Application for Removal or Variation of a Condition following Grant of Planning Permission or
Listed Building Consent

Erection of a 6 storey residential building consisting of 25no flats with 6 car parking spaces, 3 electric car charging points, perimeter landscaping and to maintain a vehicular right of way to the rear of adjoining premises as preceded by demolition of a 2 storey structure Formerly a Night Club.

(2) - Approved Drawings
(18) - Car and cycle parking

2011/ 201A

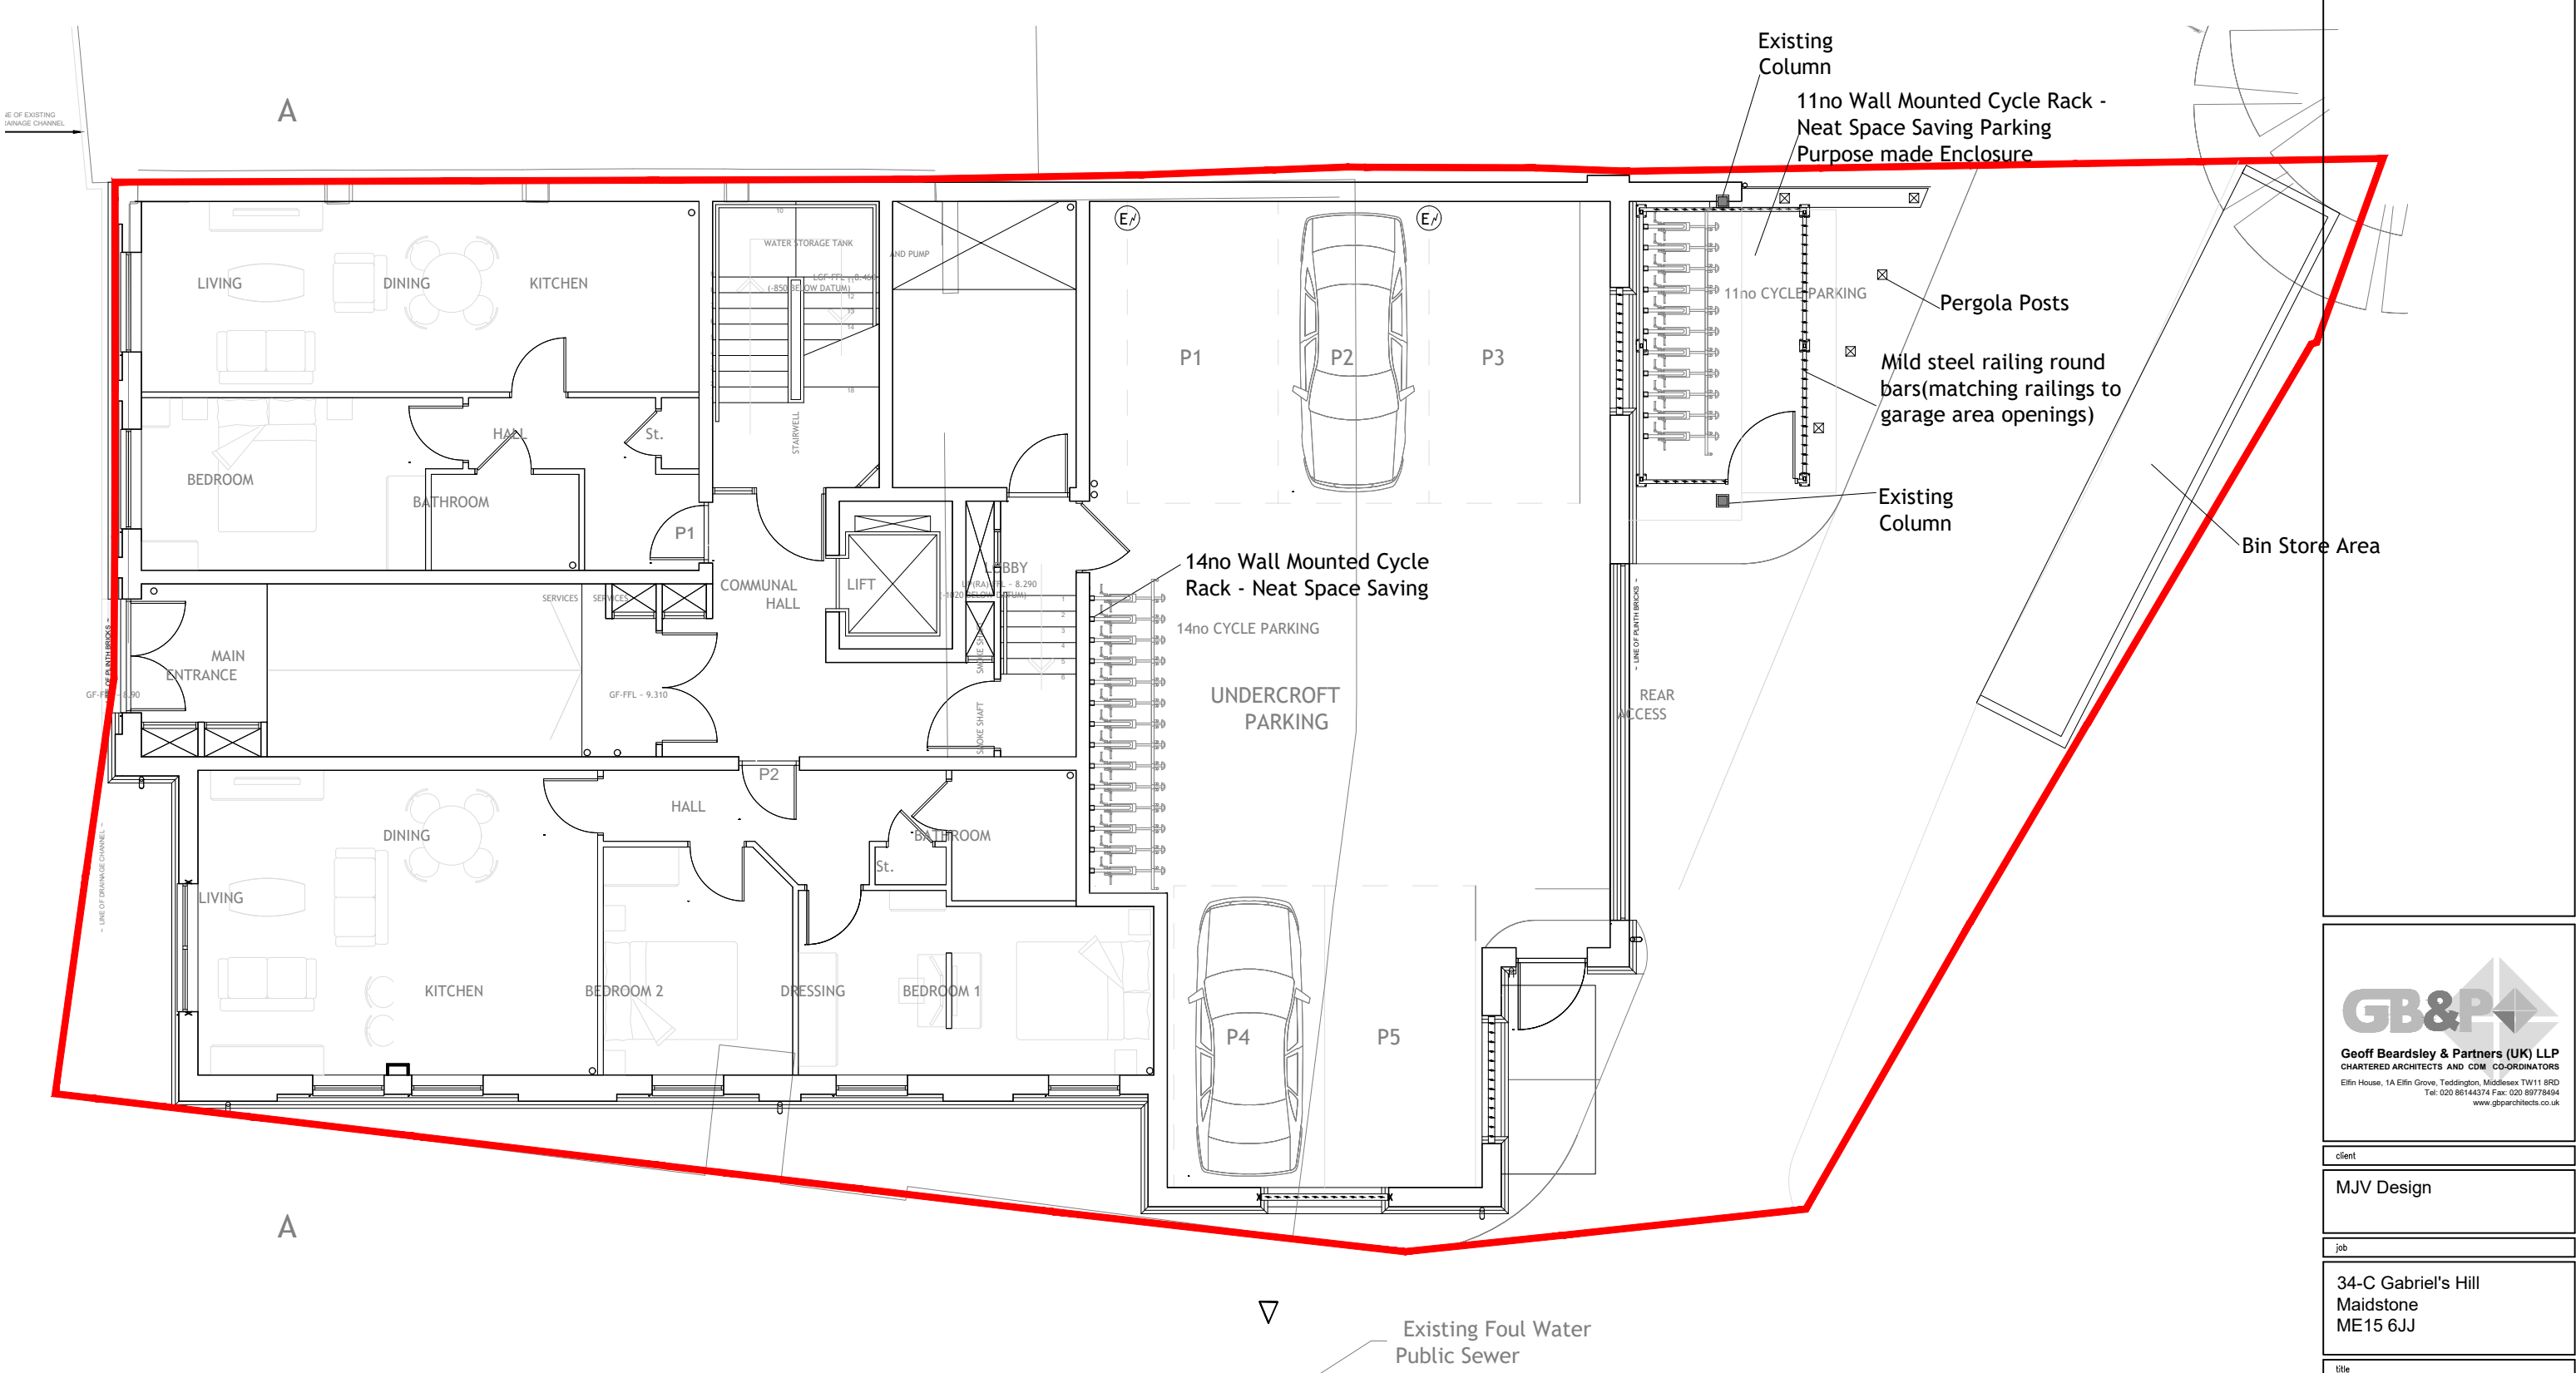
Due to the allocation of plant room machinery, the approved designated area for 25no bicycle storages has to be relocated. Also, due to the presence of two structural columns occupying the outside car parking space, it is not viable to utilize it for its intended purpose. Therefore, we propose it to be replaced with 11 bicycle storage spaces. In addition, we propose the remaining 14no bicycle storage spaces to be relocated to the undercroft parking area, totalling the required min 25no bicycle storage spaces.

2011/201A - GROUND FLOOR
